EP/34 Taronga Zoo Sky Safari**Responsible Officer: Urban Planning Team Coordinator**

A State Significant Development Application (SSD-46807958) has been lodged with the NSW Department of Planning, Housing and Infrastructure (DPHI) for the redevelopment of the Sky Safari at Taronga Zoo. The application was on public exhibition from 24 September to 21 October 2024. The consent authority for the application is the Minister for Planning and Public Spaces.

Submission – Taronga Zoo Sky Safari (SSD-46807958)

Tree management plan

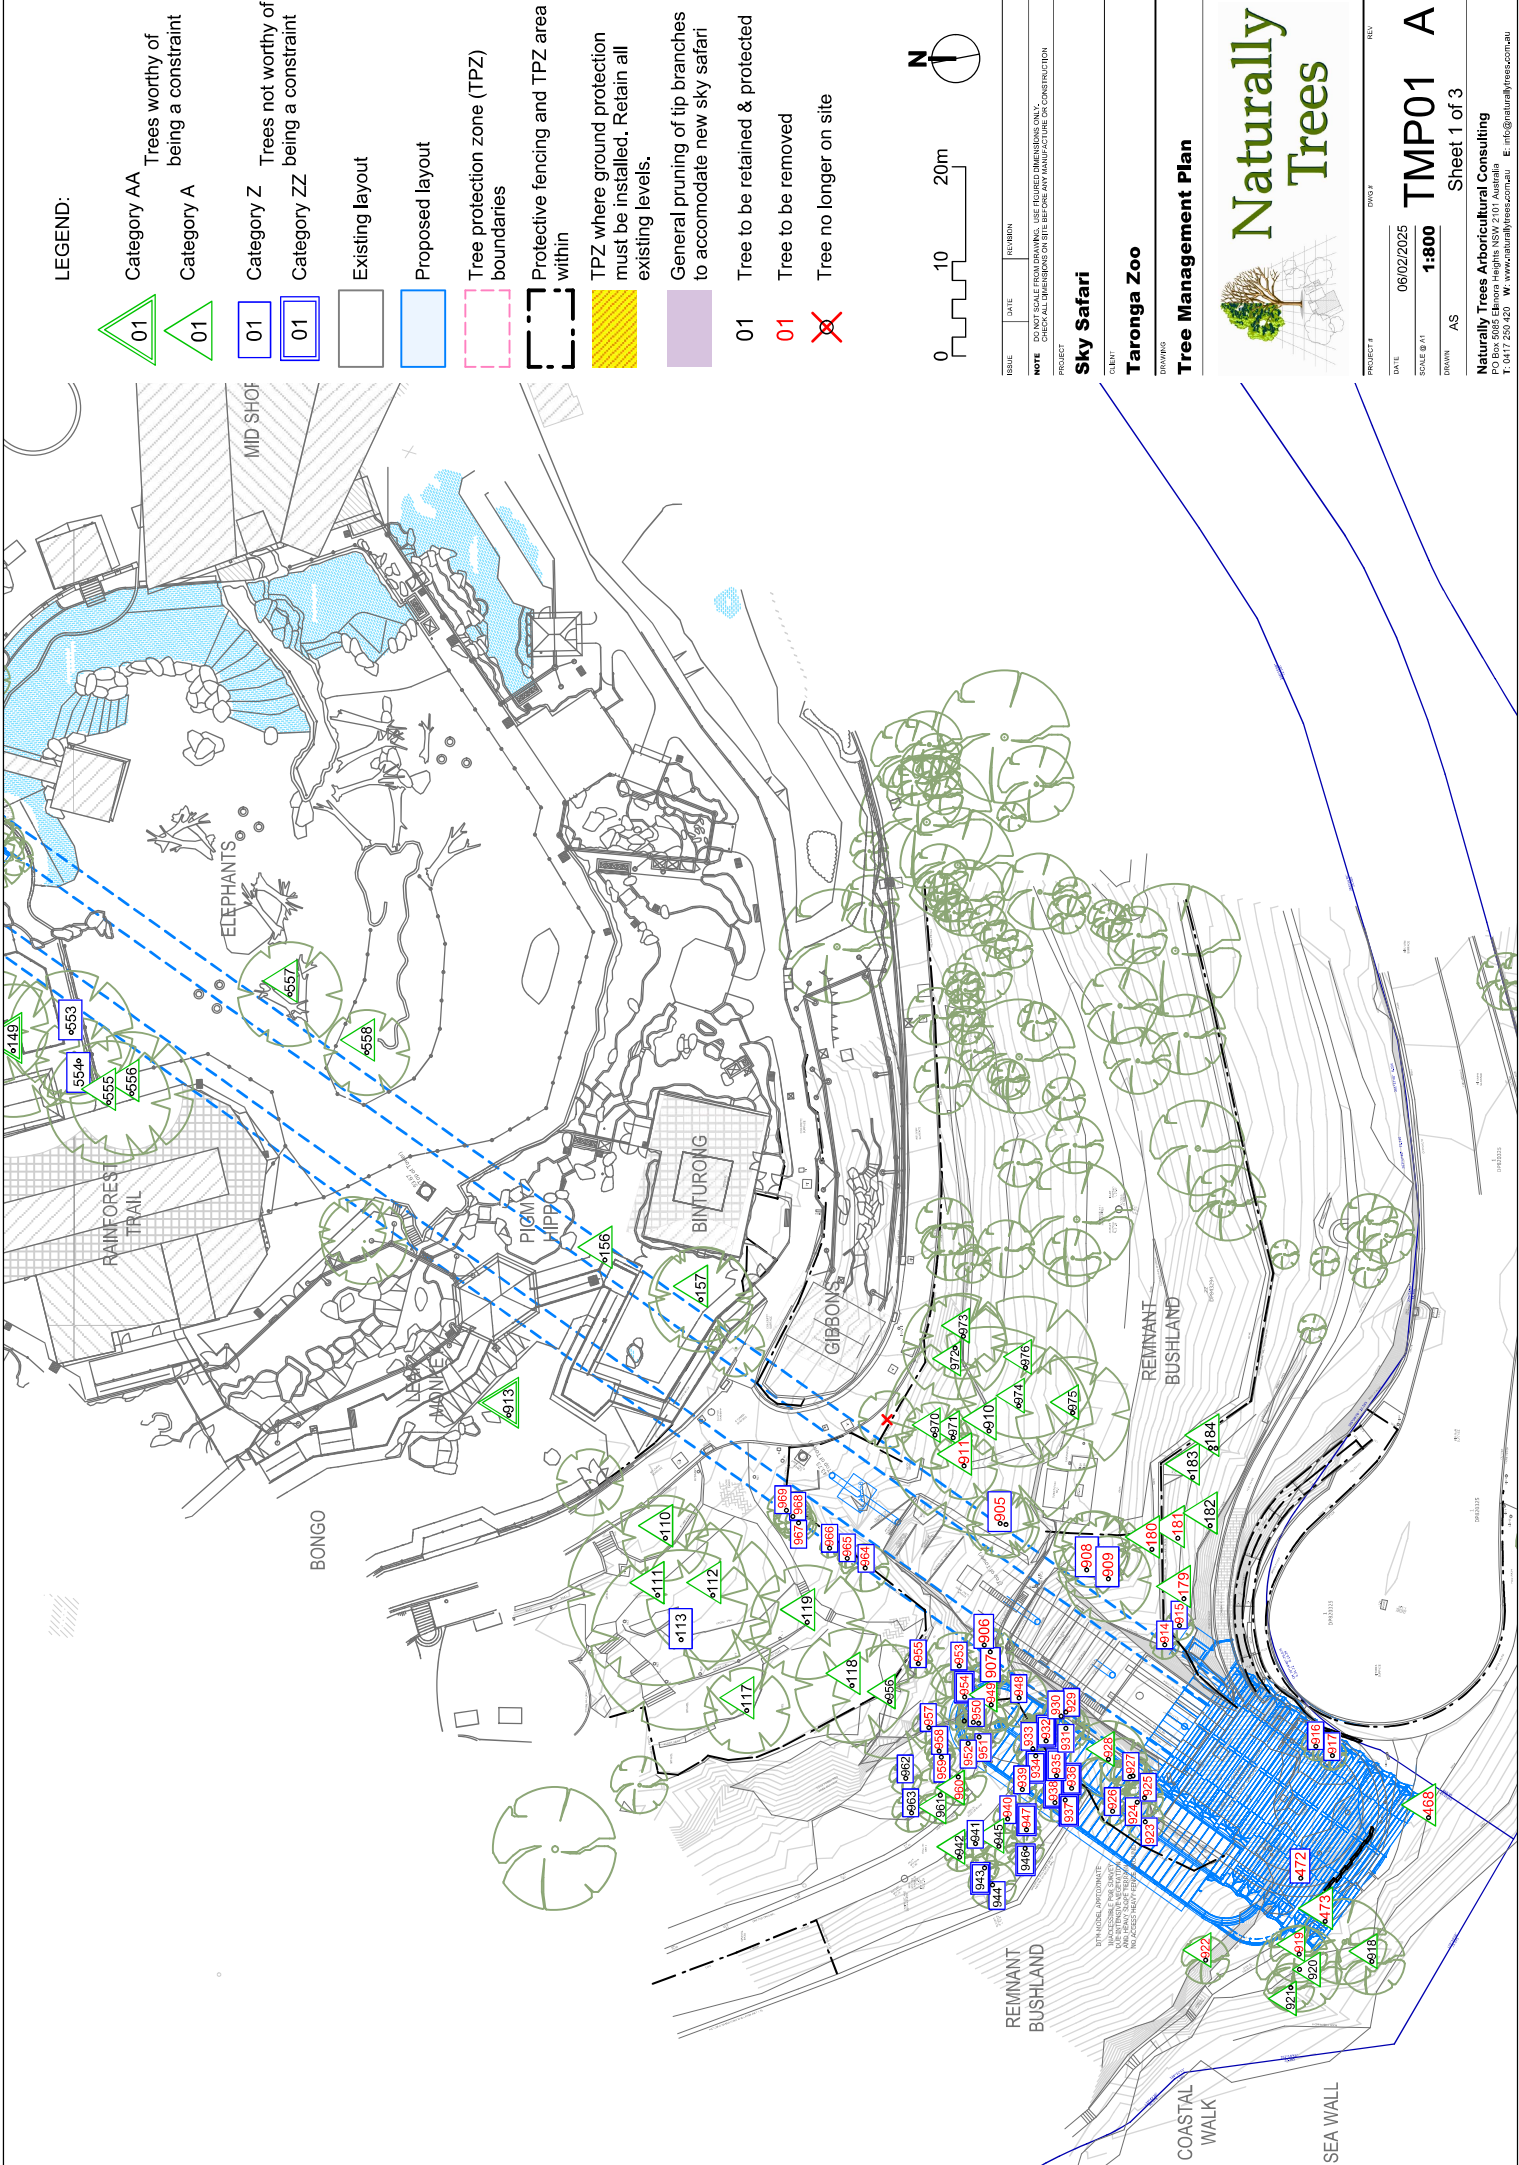
To ensure that the site maintains the dominance of landscaping over built elements, the landscape plan should include the provision of suitable replacement trees along the route to screen the structure as well as provide for a net increase in the total number of locally indigenous large canopy trees over the whole site.

A site-specific tree protection strategy should be developed to identify tree protection measures for all trees in close proximity to the works including fencing and inspection requirements during construction.

To ensure that the site maintains the dominance of landscaping over built elements, the landscape plan should include the provision of suitable replacement trees along the route to screen the structure as well as provide for a net increase in the total number of locally indigenous large canopy trees over the whole site.

A site-specific tree protection strategy should be developed to identify tree protection measures for all trees in close proximity to the works including fencing and inspection requirements during construction. Council strongly encourages the retention and pruning of existing trees rather than replacement.

SECTION - PYLON ROUTE

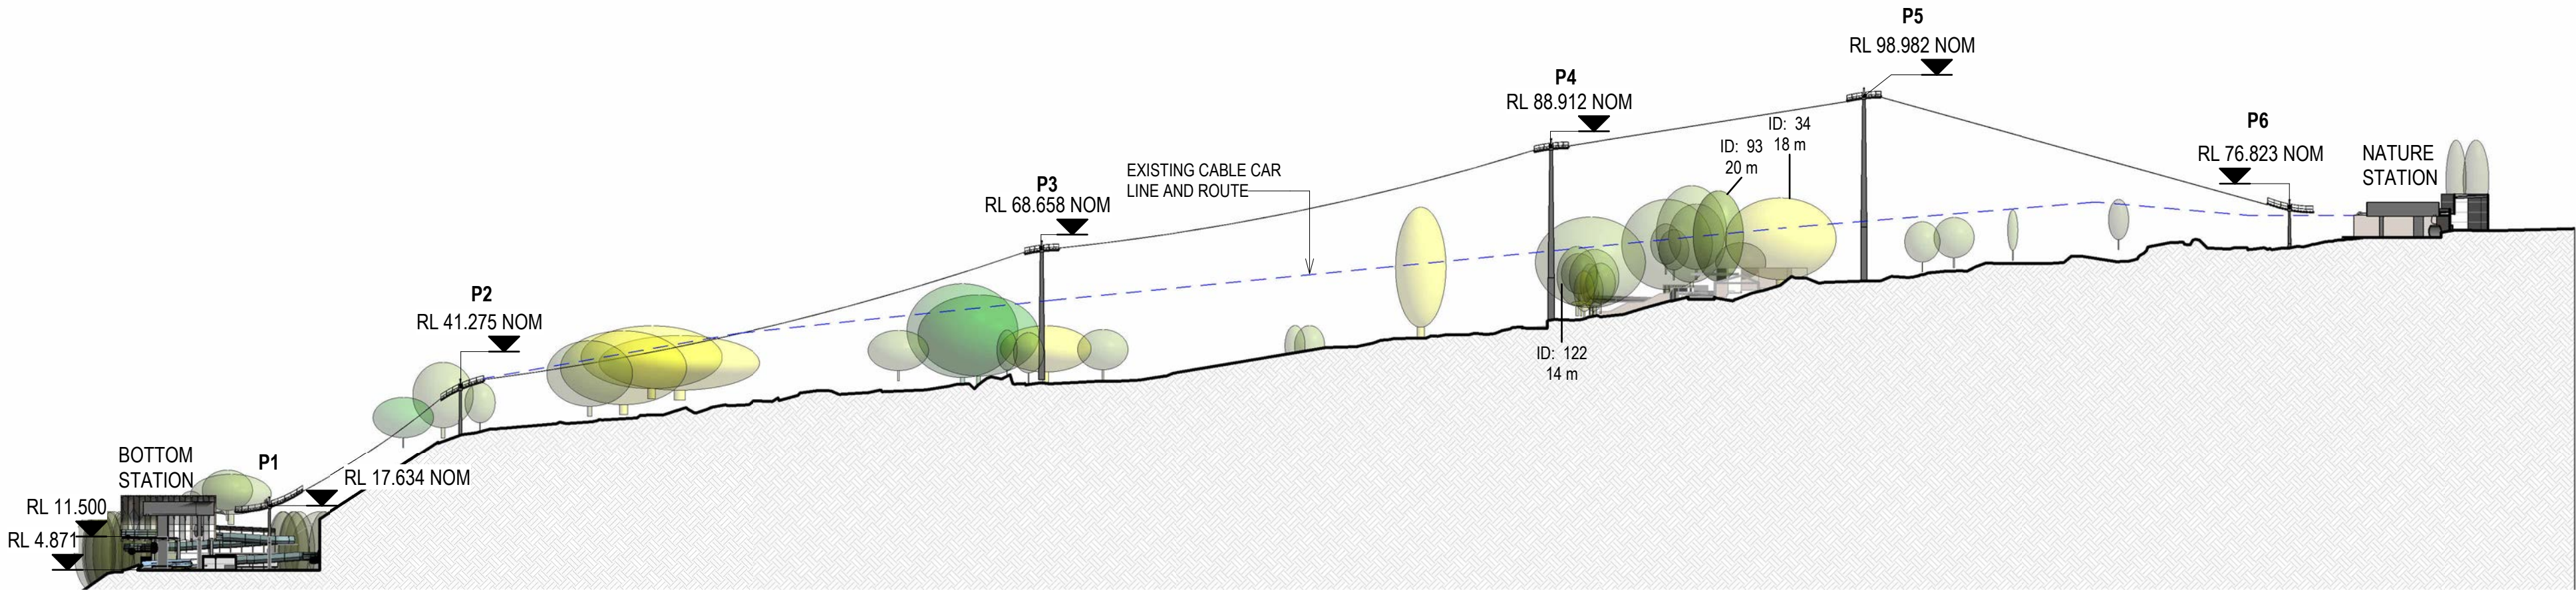
The proposal has undergone significant design changes to reduce the scope and minimise the visual impact since originally being presented to Council through the early engagement process. While the current proposal utilises the existing cable car route rather than an expanded route around the Zoo as previously proposed, the width of the route has been increased from 9m to 12.5m to accommodate the larger cable cars. The height of the pylons has also been increased compared with the height of the existing cable line to accommodate the larger cars and to provide clearances above existing significant trees.

- *Remaining incursion of pylons (P2-P5) above the prevailing tree canopy line are necessary for structural safety and operational reasons, and as such are unavoidable in service of the proposal’s current intent.*

Based on the information provided in the VIA and the need to provide clearances from significant trees, it is accepted that there is justification for an increase in the height of the Sky Safari. To mitigate the visual impact of the proposal, conditions should be imposed requiring materials, finishes and colours to be used which have a dark earthy tone and low reflectivity. This should apply to the pylons, stations and supporting infrastructure as well as the cable car exteriors.

To mitigate the visual impact of the proposal, conditions should be imposed requiring materials, finishes and colours to be used which have a dark earthy tone and low reflectivity. This should apply to the pylons, stations and supporting infrastructure as well as the cable car exteriors.
